**Benjamin Wallace - Re: FW: 2211 Congress St - Unum HO1 - permit 2013-00458**

**From:** Benjamin Wallace [<mailto:wallaceb@portlandmaine.gov>]  
**Sent:** Thursday, April 25, 2013 11:01 AM  
**To:** Brian Curley  
**Cc:** Jeanie Bourke  
**Subject:** 2211 Congress St - Unum HO1 - permit 2013-00458

REGISTERED ARCHITECT
BRIAN
12-124
PDT JOB NO.
DRAWN
JKP
SCALE
1/16" = 1'-0"
ISSUE: 29 APRIL 2013
IFC SET
TITLE
HOI-BASEMENT FLR.
PHASING & CODE
DIAGRAMS, CODE
SUMMARY & LEGEND
SHEET
A-001

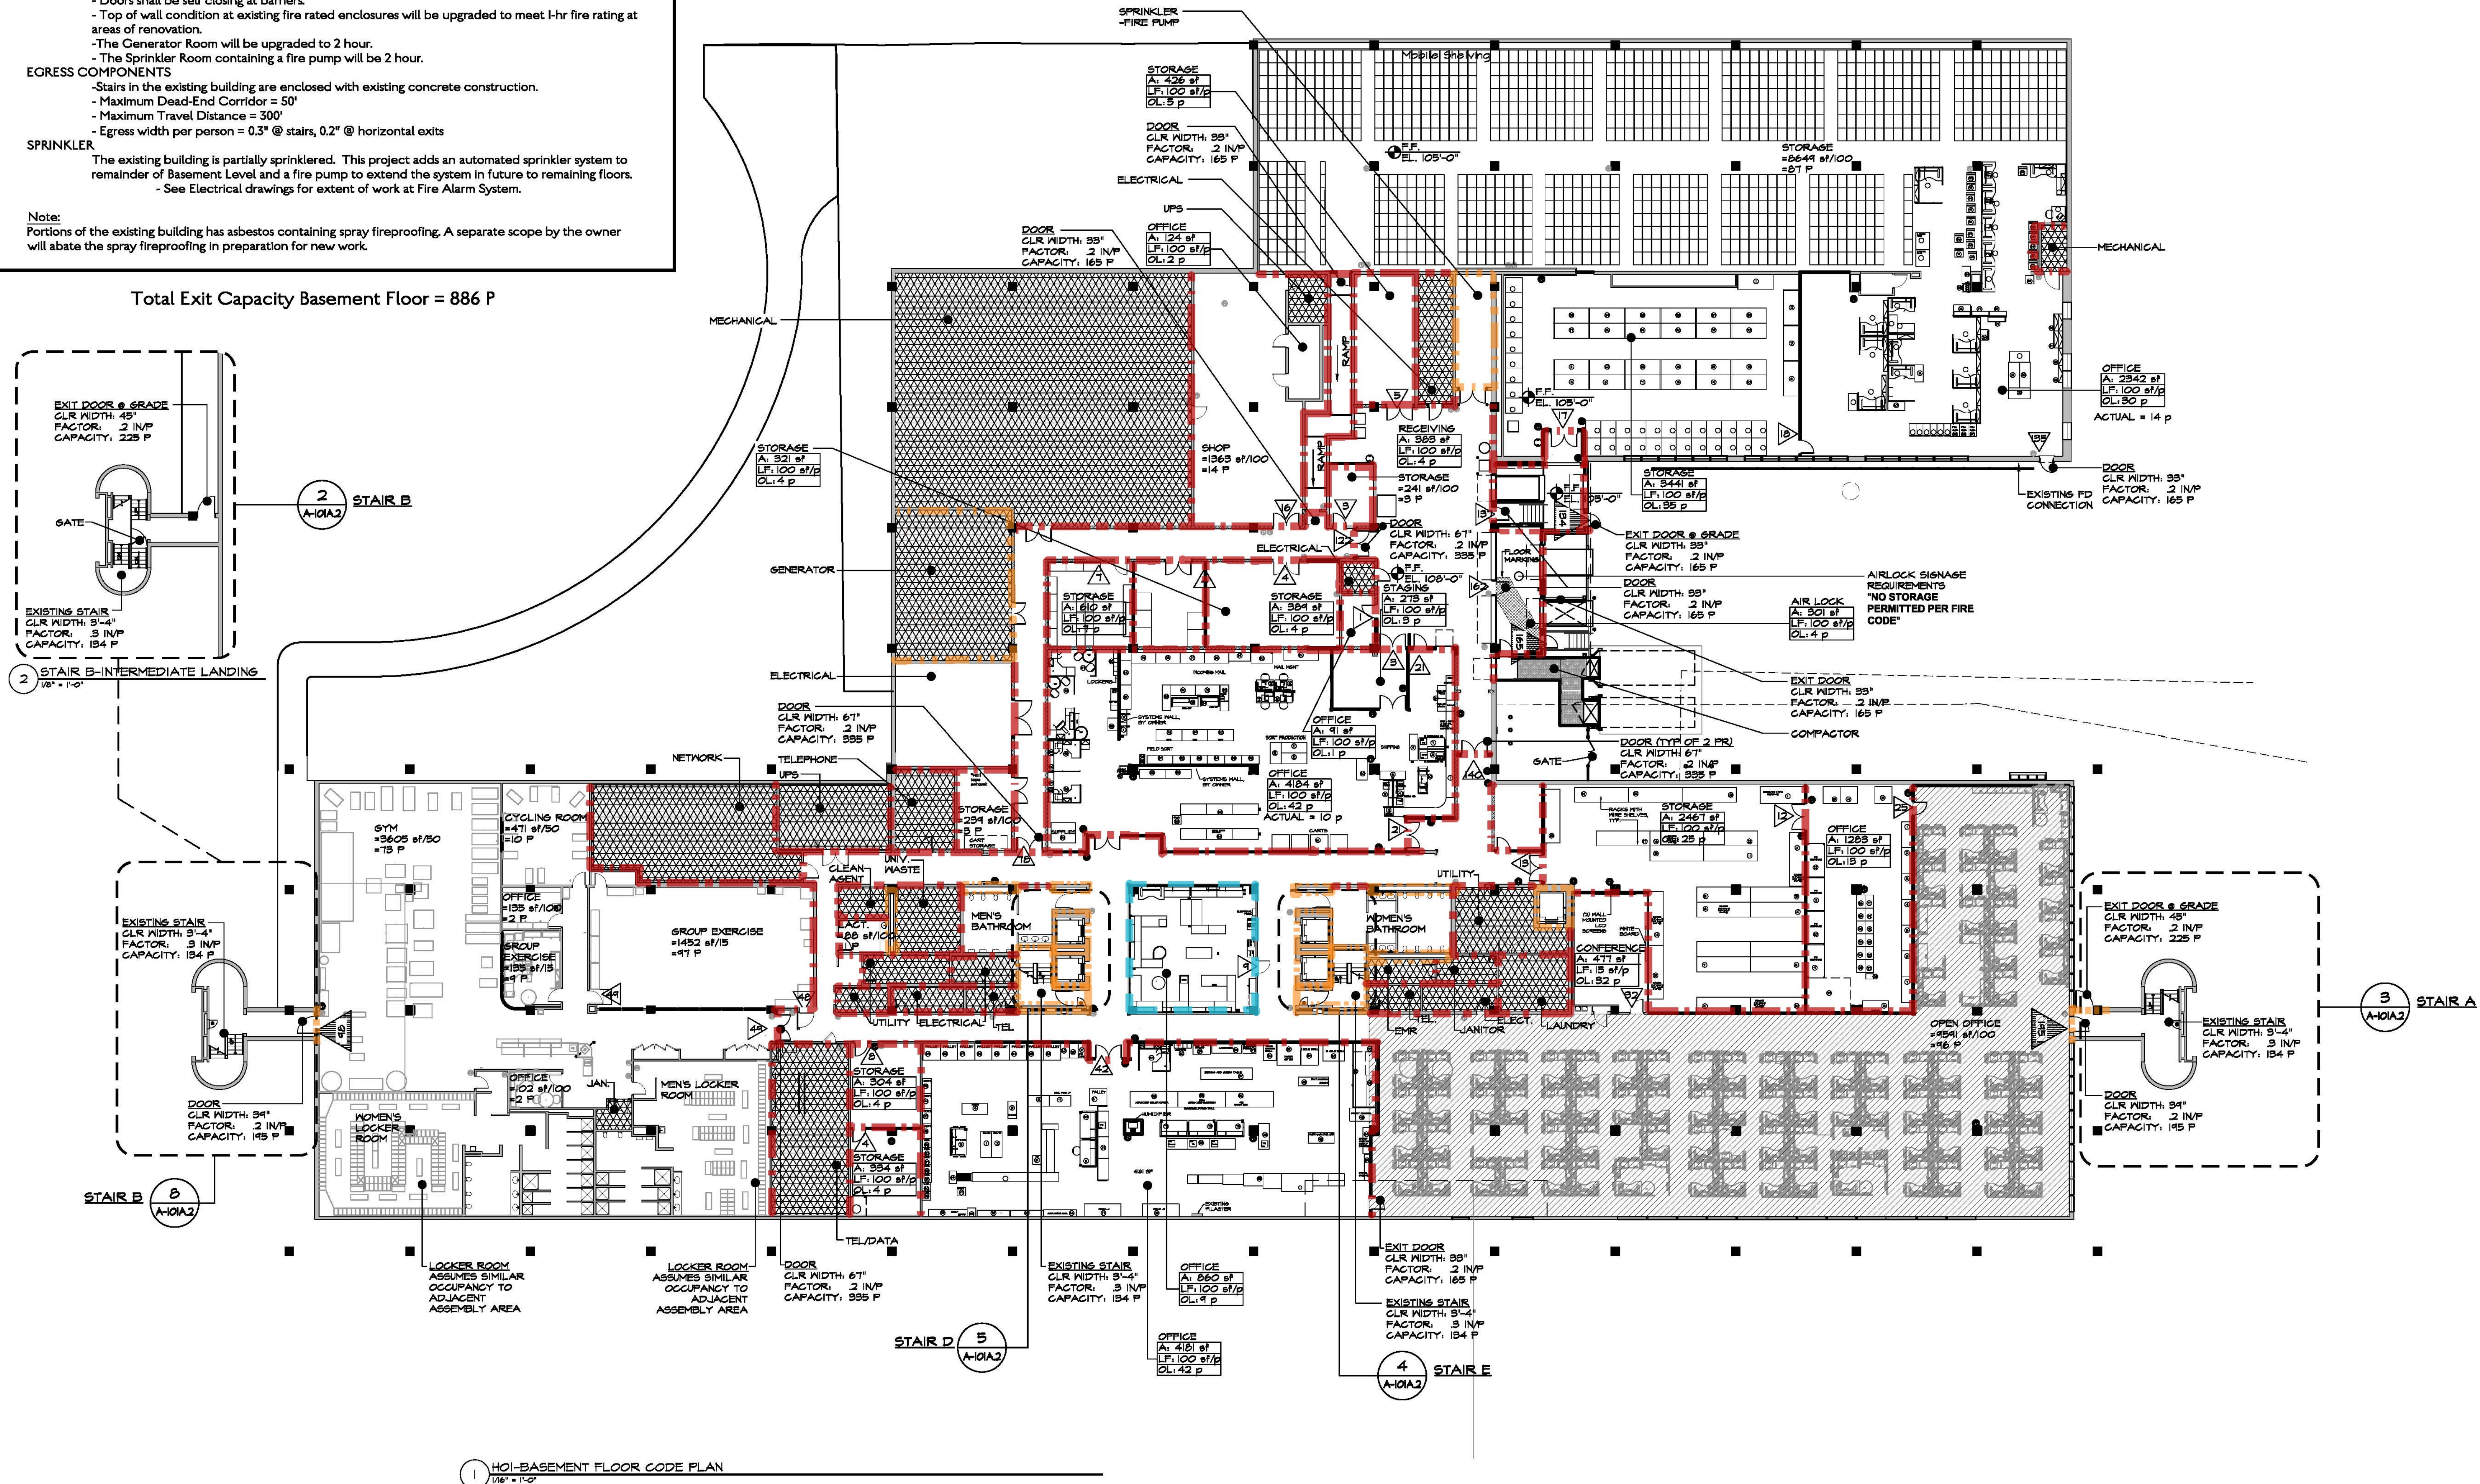
- Many sheets show exit sign arrangements that don't match the egress plan on sheet A-001. In particular the reflected ceiling and electrical plans indicate exit signs directing occupants to Stairs D and E.

- One of the egress routes shown on Sheet A-001 travels through Air Lock B070 which is actually a loading dock. I can deal with that provided there is permanent signage posted in the space that states NO STORAGE PERMITTED PER FIRE CODE and the egress path is stripped from door to door.

ITEM 6 - We will add the described Signage and Floor Markings. **Please provide updated sheet A-001 showing the striping and a note indicating such change.**

1 HOI-FIRST FLOOR CODE PLAN
1/8" = 1'-0"

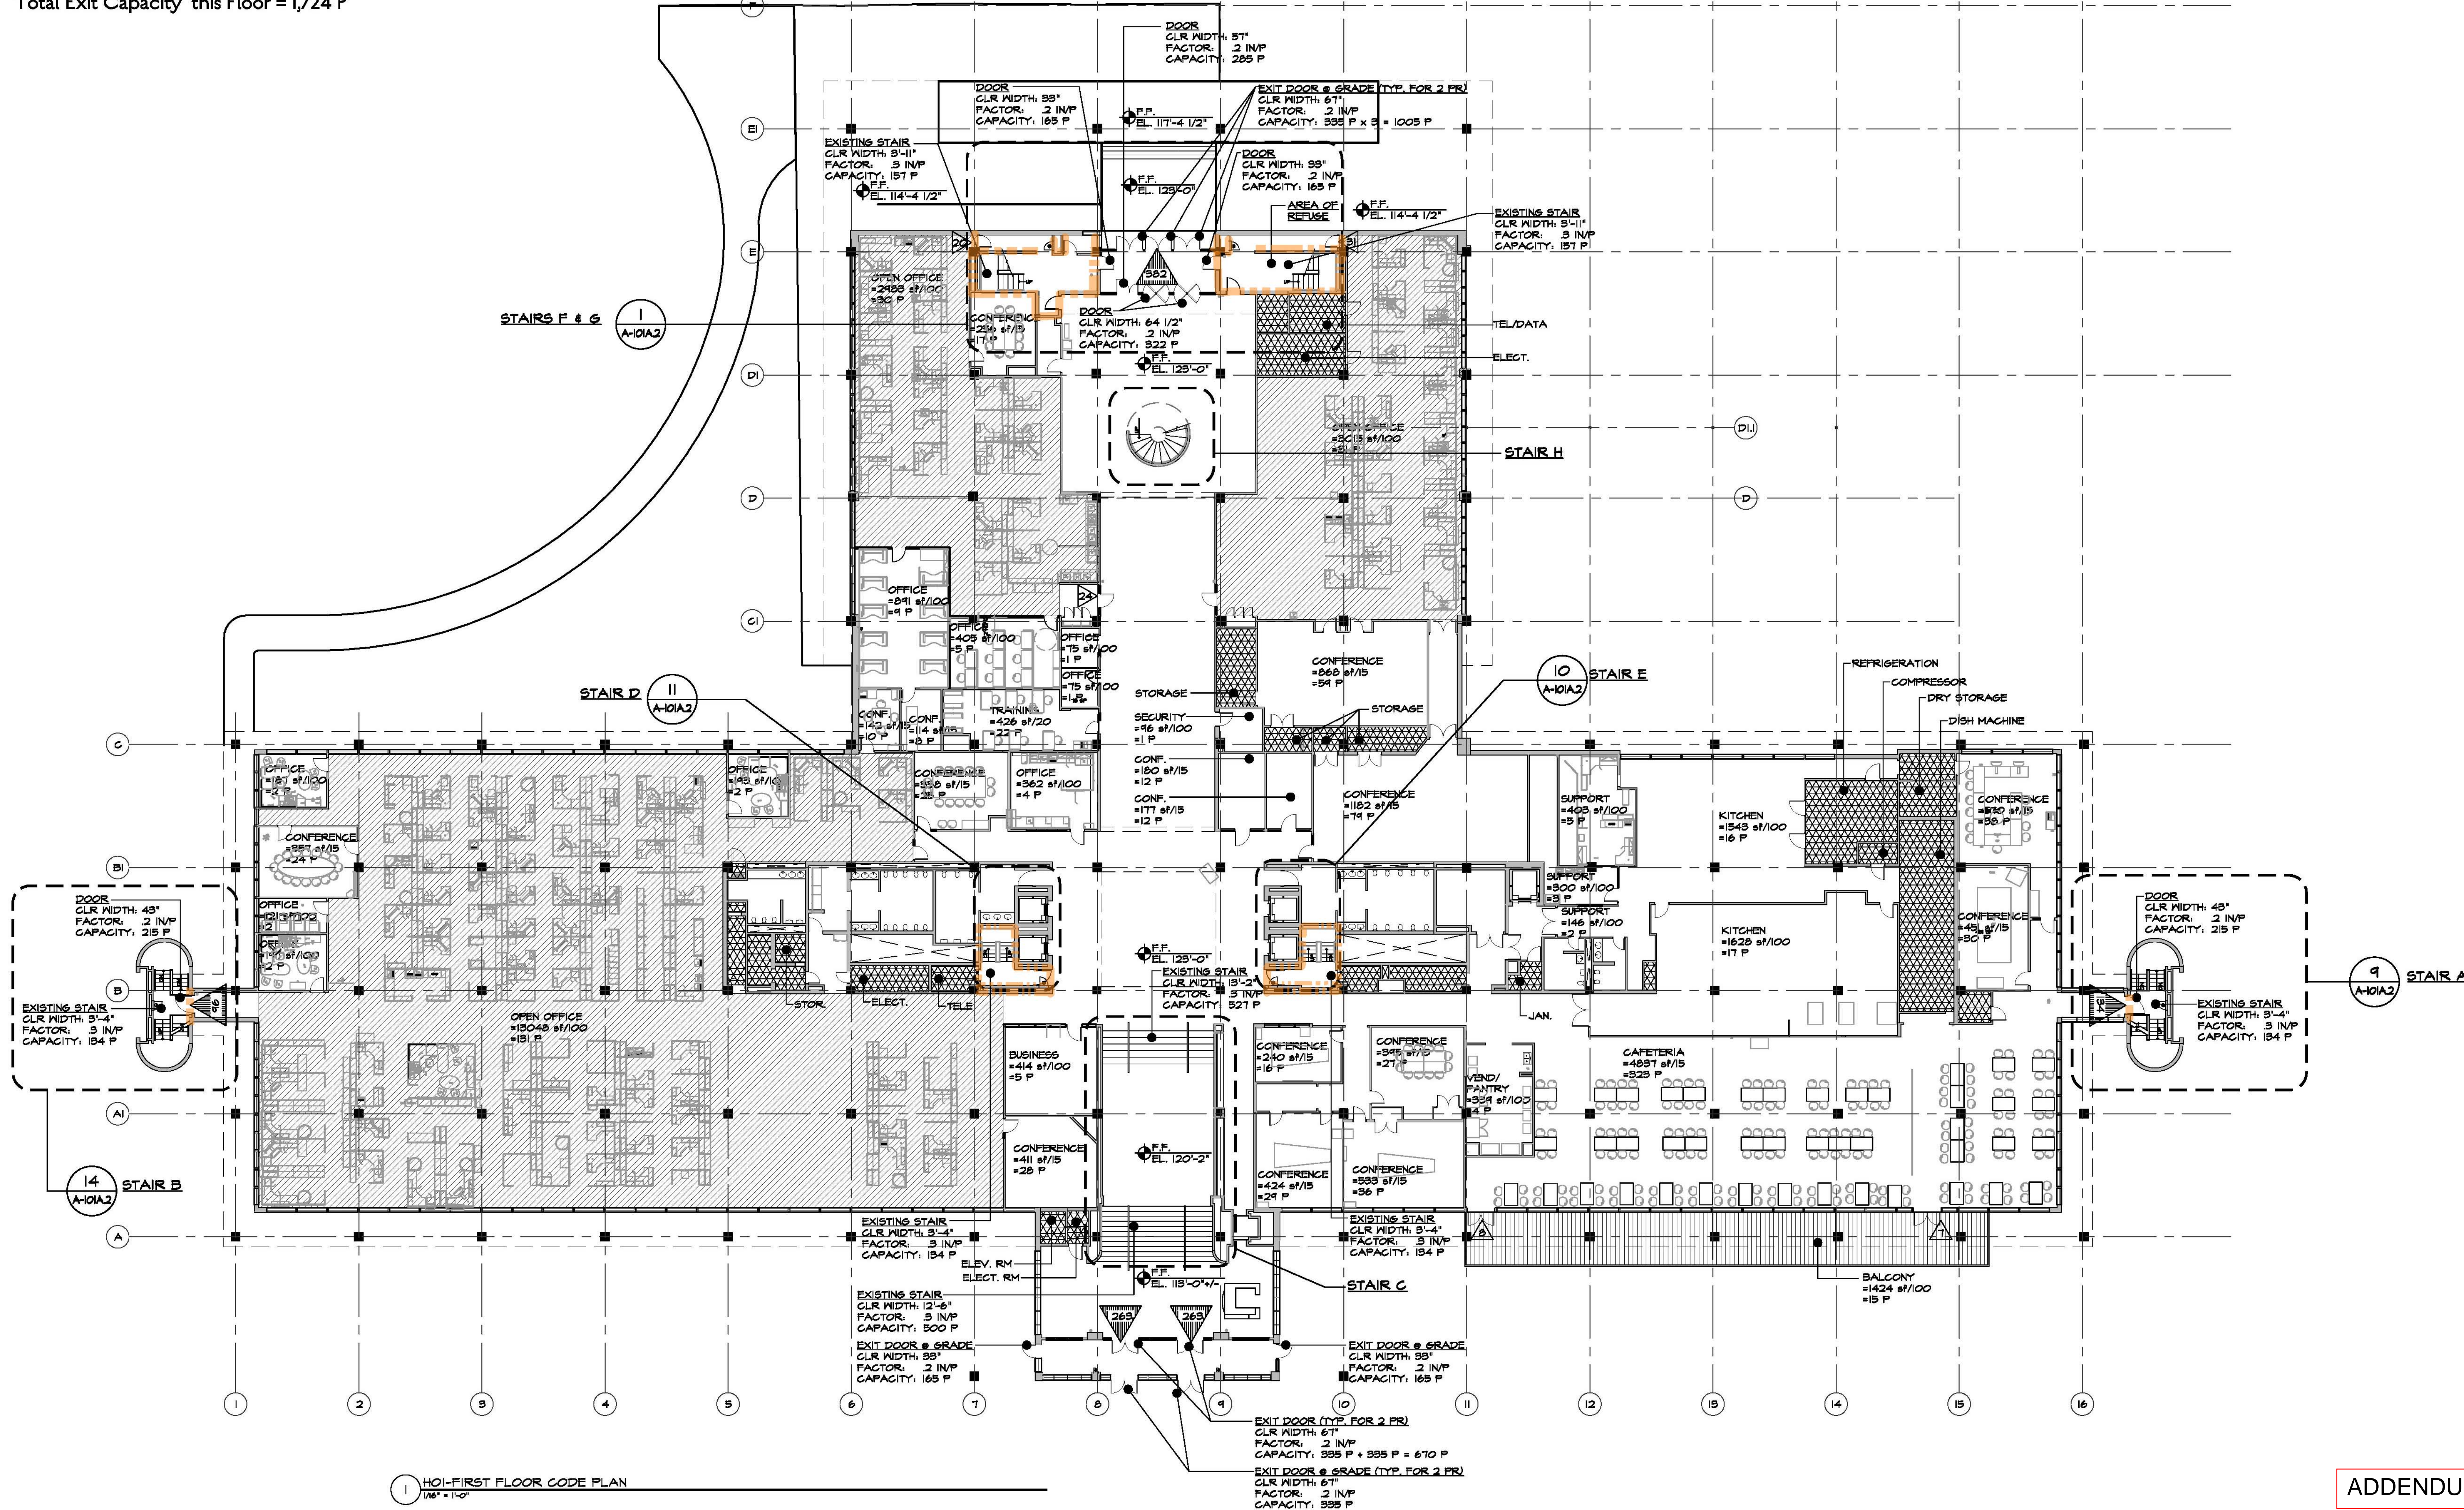
- The mercantile space on sheet A-002 adjacent to the South entrance shows an occupant load factor of 100. The proper occupant load factor for mercantile is 30 per NFPA 101:7.3.1.2. This is informational only. I recognize the second floor is not within the scope of work but it is shown as a part of your egress plan for the building.

Noted. **Ok. I suspect it is likely the case but please verify the minor increase in the occupant load does not exceed the exit capacity you've indicated.**
